Mr Brad Campbell
Bursar
THE TRUSTEES OF THE SYDNEY GRAMMAR SCHOOL
SYDNEY GRAMMAR SCHOOL
10-12 COLLEGE STREET
DARLINGHURST 2010
19/05/2021

Weigall Sports Complex, Sydney Grammar School (SSD-10421)
Request for additional information

Tree Canopy Coverage. Existing

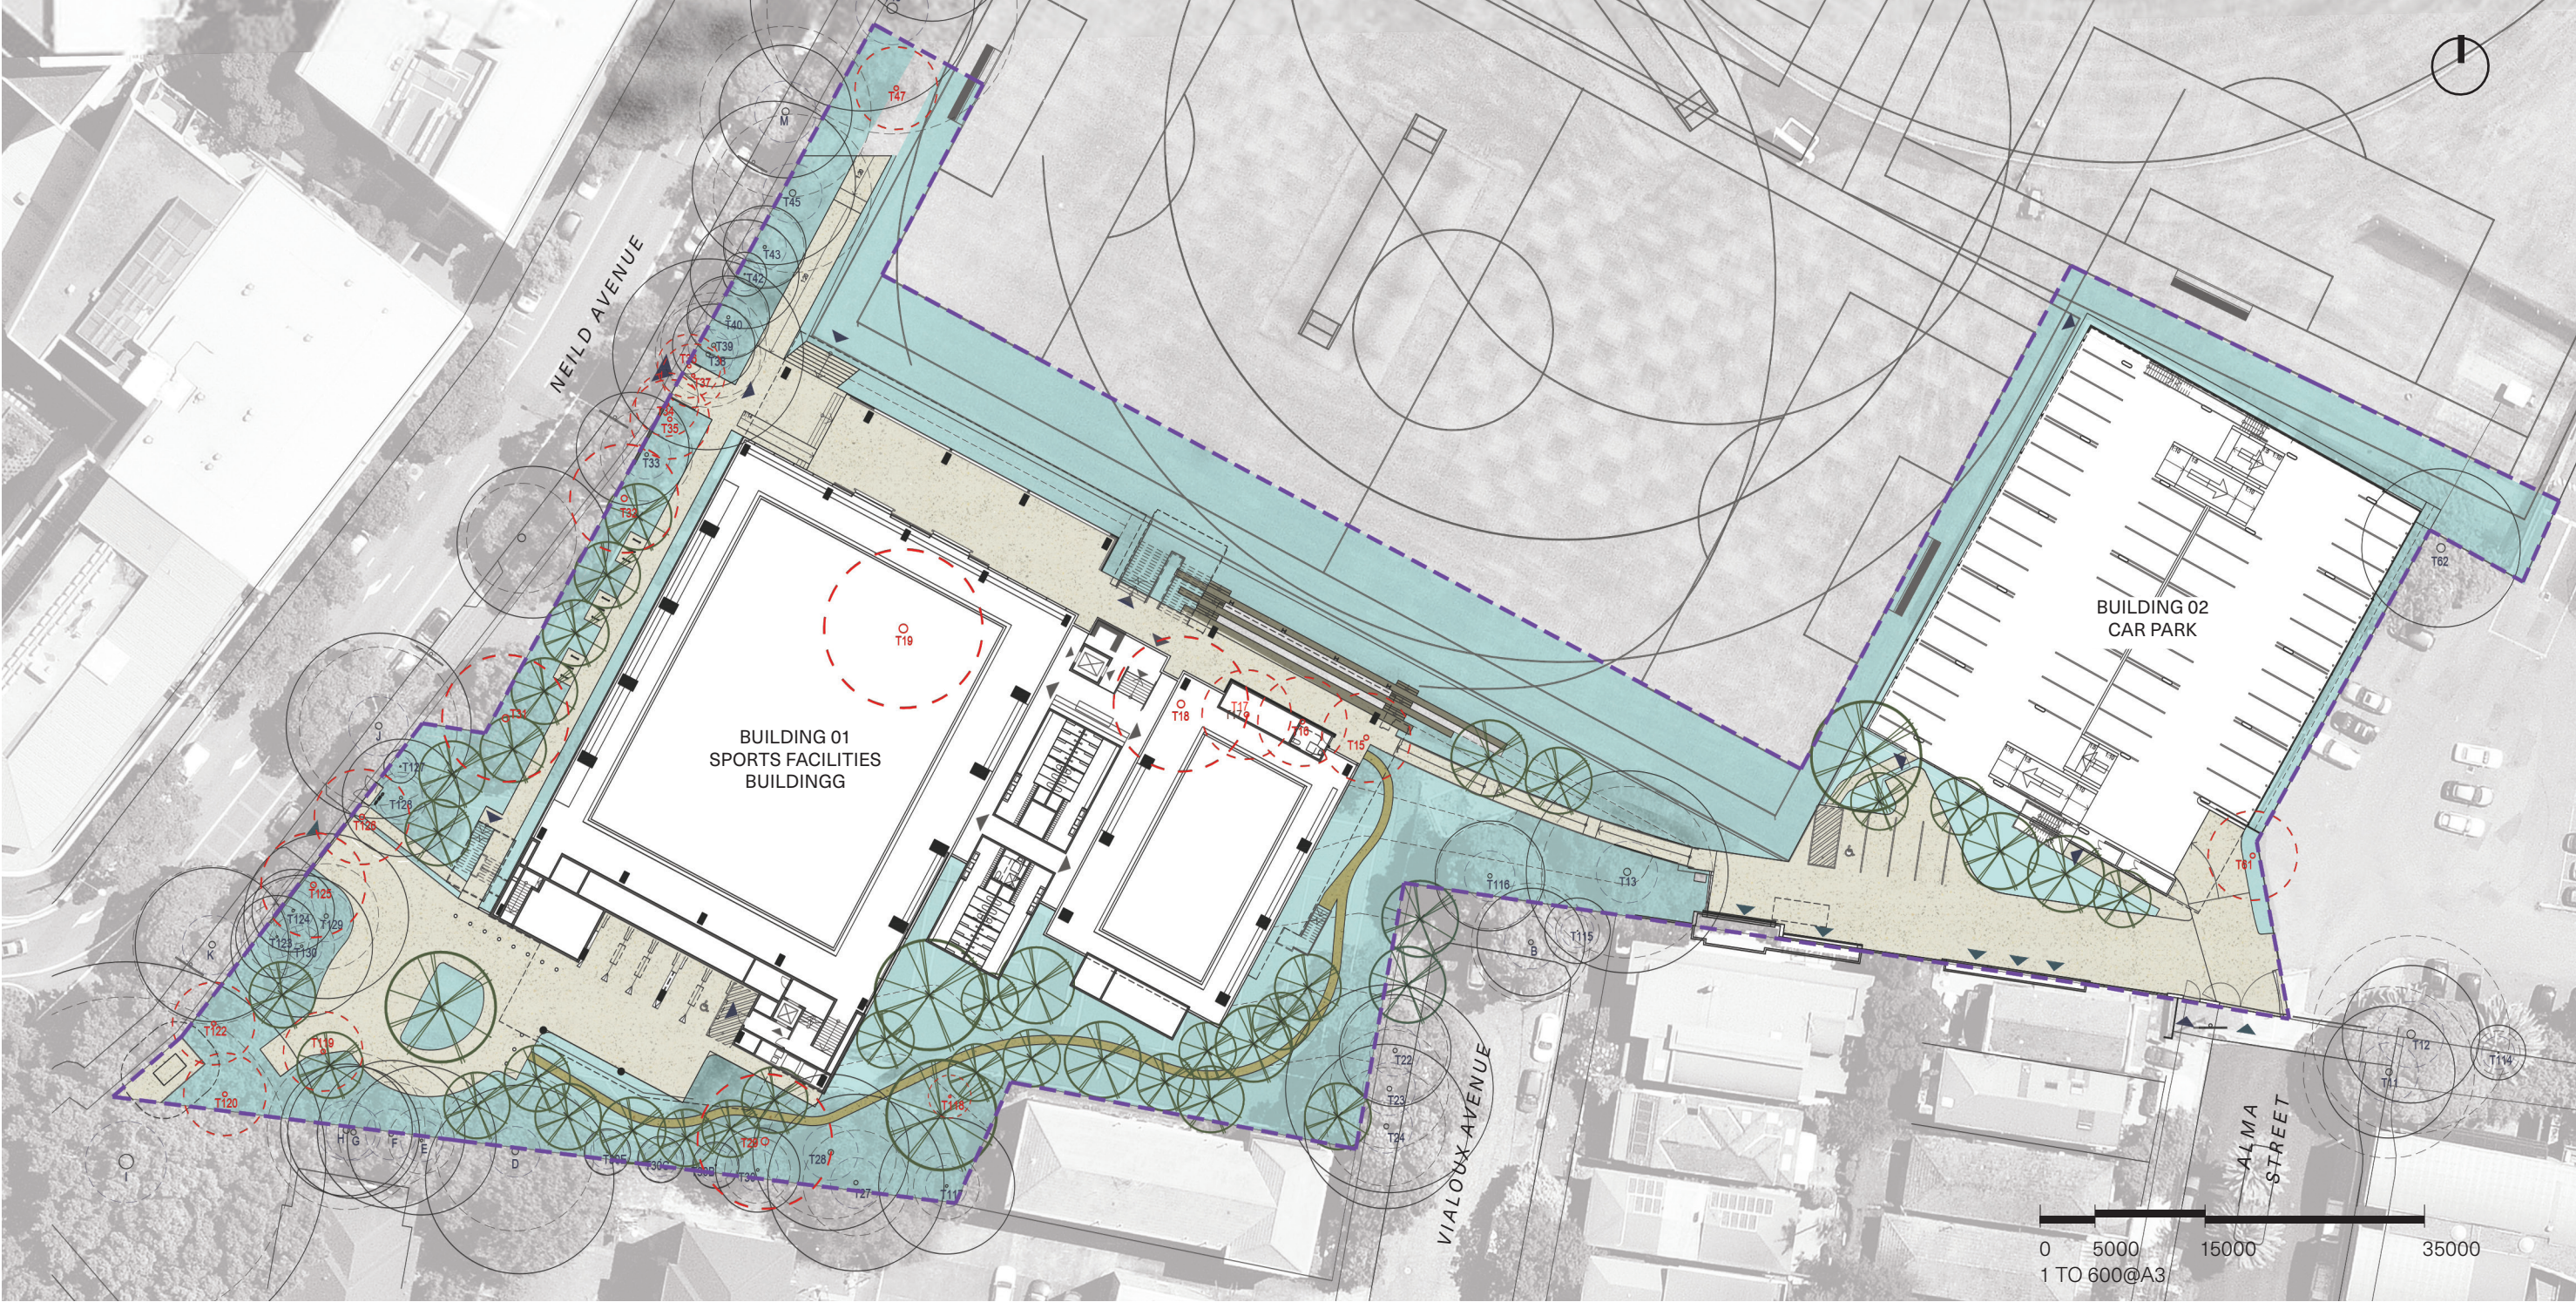
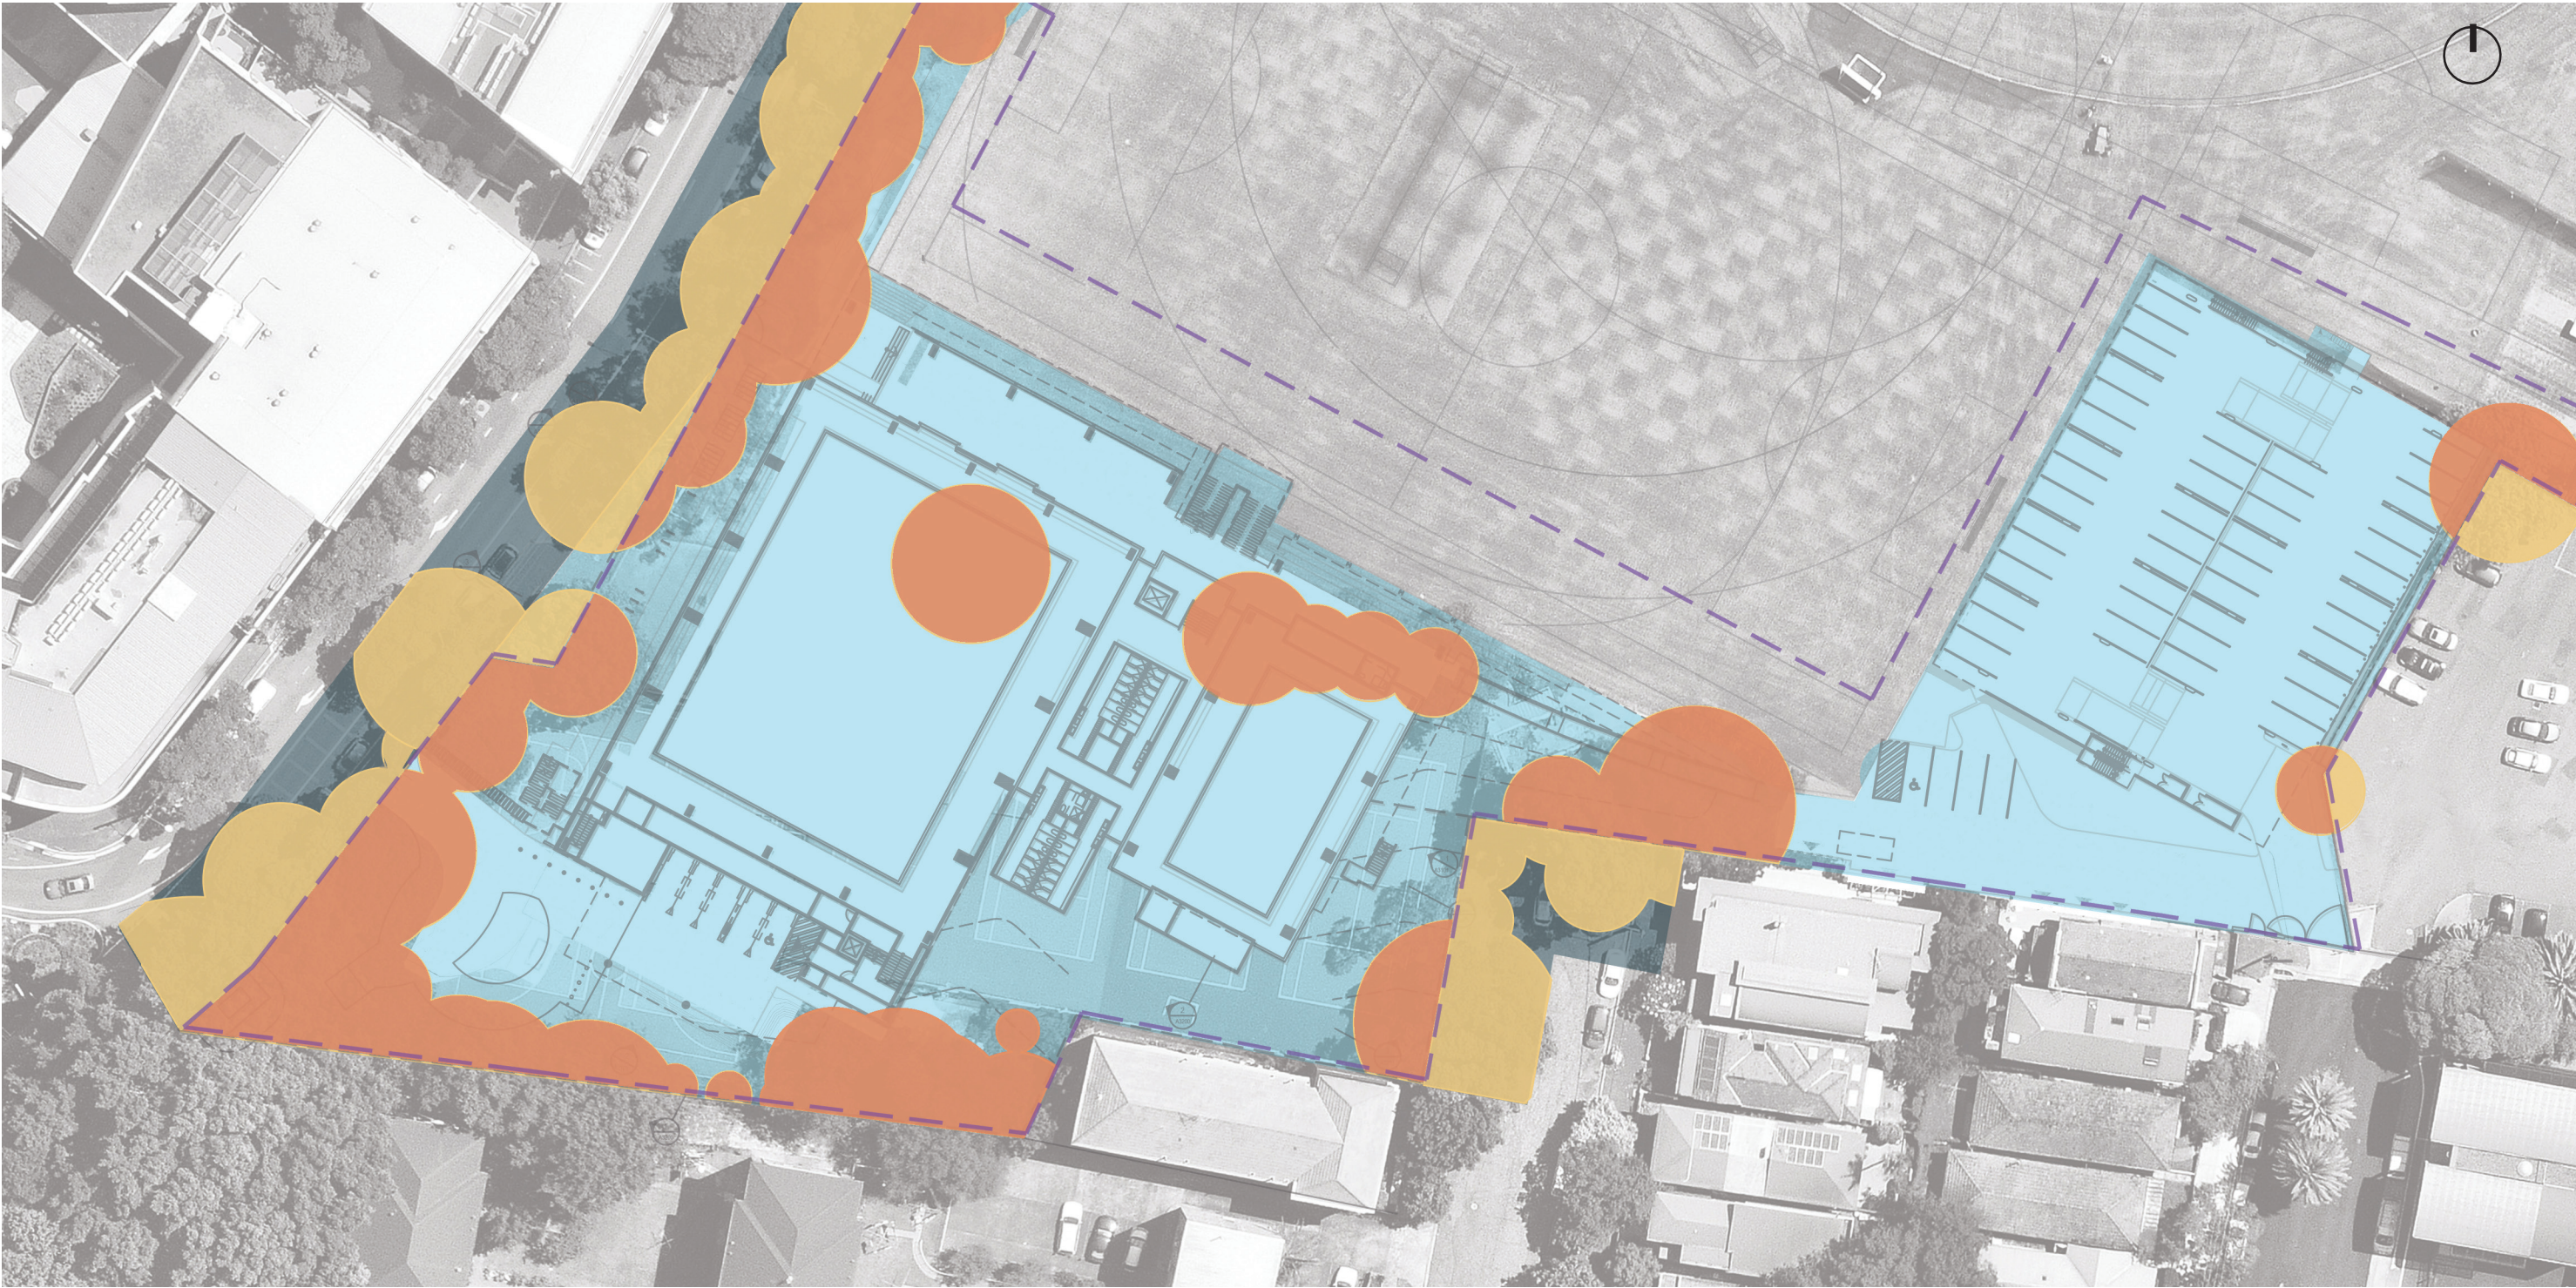
Provide an update of Figure 54 of the EIS (page 55) to confirm the 'as-existing' tree canopy coverage and confirm the difference between the existing and proposed cover in square metre and as a percentage.
